# CITY OF ALBUQUERQUE

PLANNING DEPARTMENT – Development Review Services

April 28, 2016

RE: **Winrock Town Center – Phase A, Pad 2 (J19D058D)**  
**Grading Plan, Engineer's Stamp Date: 4-14-2016**

TITLE: GRADING P

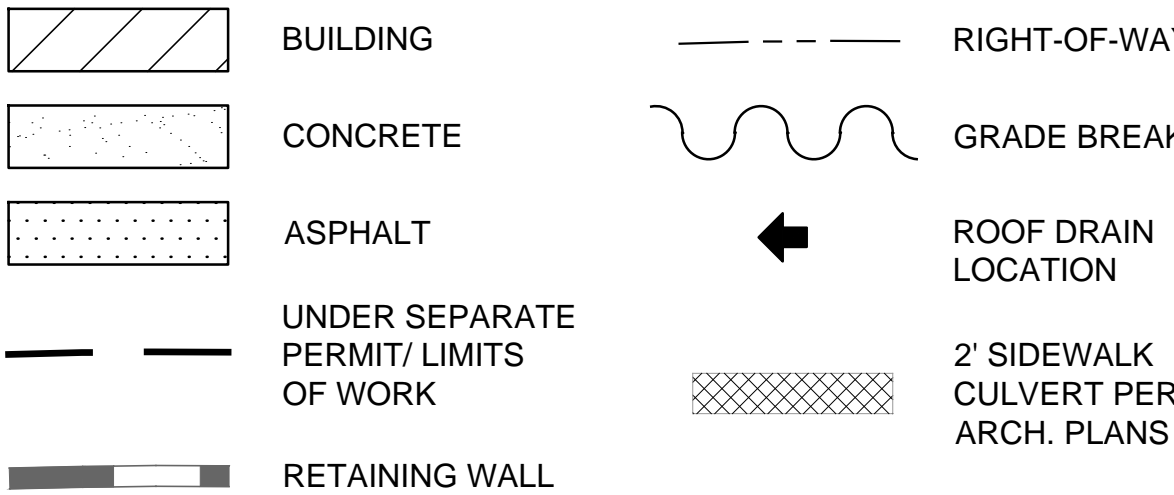
- Grading and Drainage plans should reference the master drainage plan or other sources that indicate the intended drainage for that area. The applicant should provide excerpts from the supporting documents and/or grading plans.
- Provide a Drainage Reports with all supporting documentation
- Supporting documentation should include:
  - Allowable discharge from the site
  - Allowable discharge points
- Provide calculations for first flush, and show locations and volumes provided on the plan
- Site vicinity map to be enlarged, showing location of development within the Winrock Site.
- Show existing and proposed contours
- Indicate how this development is intended to be phased in. It is understood that all of Winrock is to be phased. What phase is this? Does it fall within the phased plan per the Drainage Master Plan?
